Recommendation Report for Planning Permission for Works or Extension to a Dwelling

REF NO: M/56/17/HH

LOCATION: 8 Beaconsfield Close
Middleton-On-Sea

PROPOSAL: Demolition of existing flat roof garage & construction of replacement single storey pitch roof side & rear extensions

Title
Elevations as Proposed

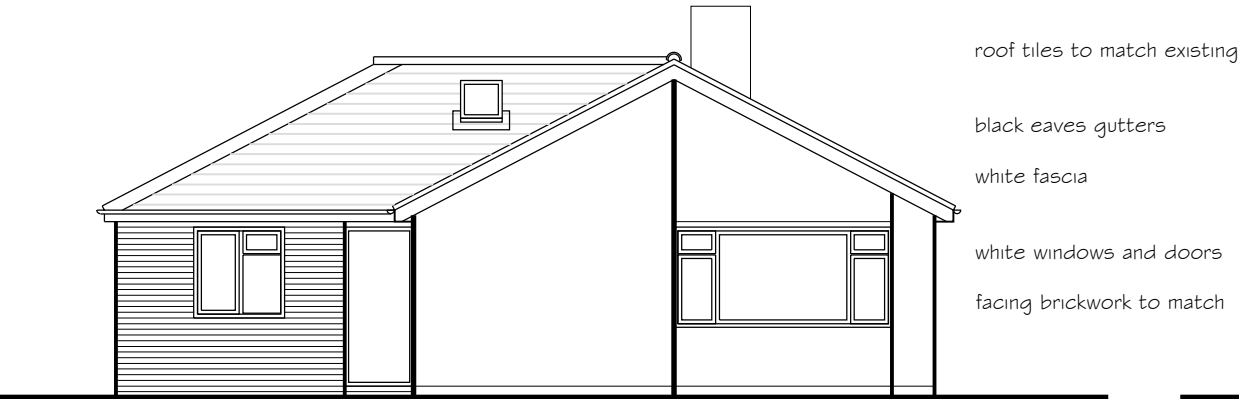
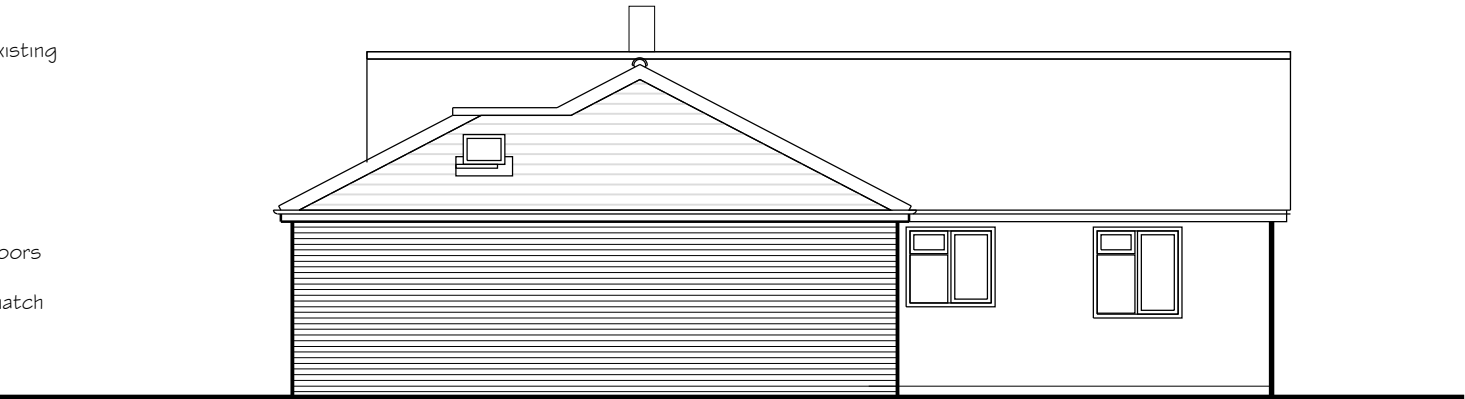
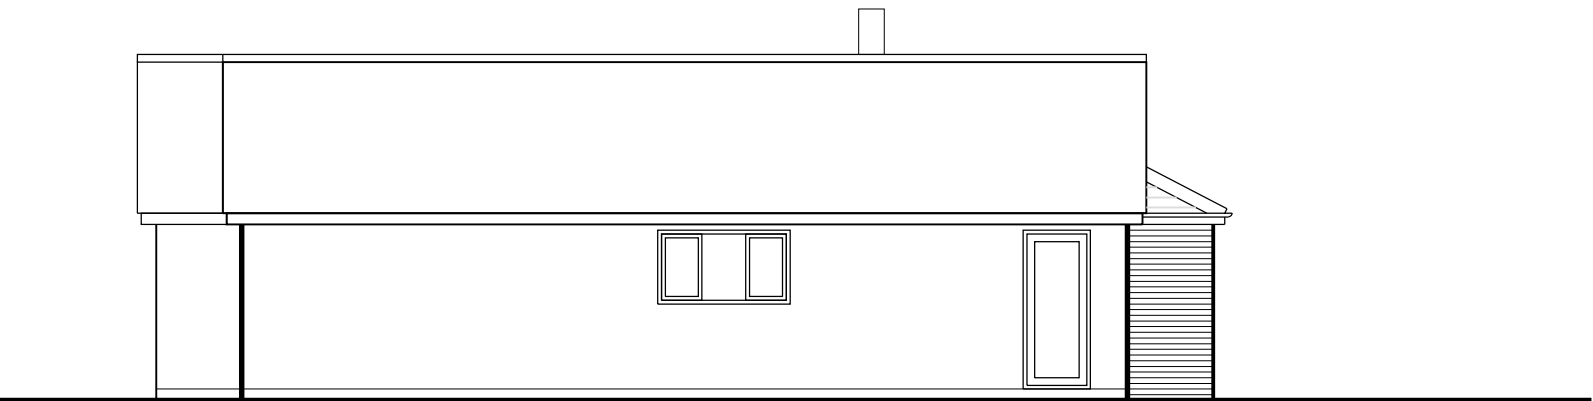
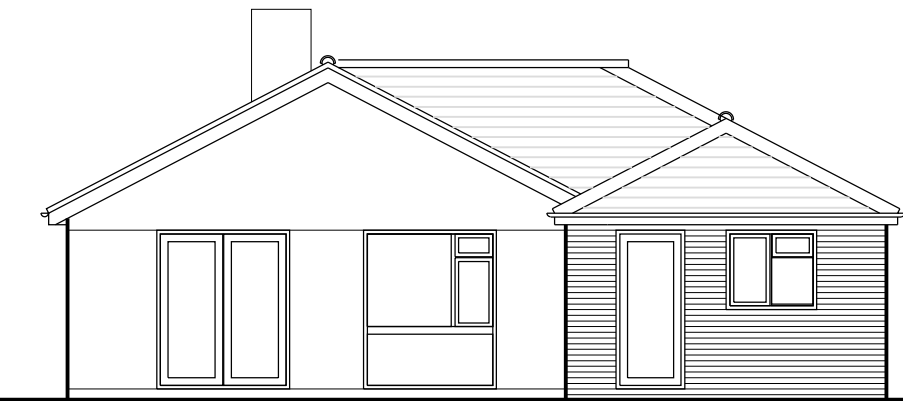
The proposed single storey side extension is sited approximately 5m behind the front elevation of the existing house and 12.5m from the front boundary of the site. The extension would be built up to the boundary with No.10 and replaces the existing single storey flat roof garage. The extension would have a height in line with the existing ridge line of the house when viewed from the front, this is reduced to the rear. The extension would be visible from the street. Materials are to match the existing house.

With regard to the amenity of adjoining occupiers the proposed extension would be built up to the boundary with the property to the north No.10. There are no side windows in the proposed extension and the rear window is at ground floor level therefore there would not be an unacceptable level of overlooking to No.10. Given the existing garage and the height of the proposed extension, albeit the pitched roof increases the overall height, the eaves height is comparable to the height of the existing garage. Therefore, it is not considered that the proposed, amended, extension would be harmful to the amenity of adjoining occupiers at No.10.
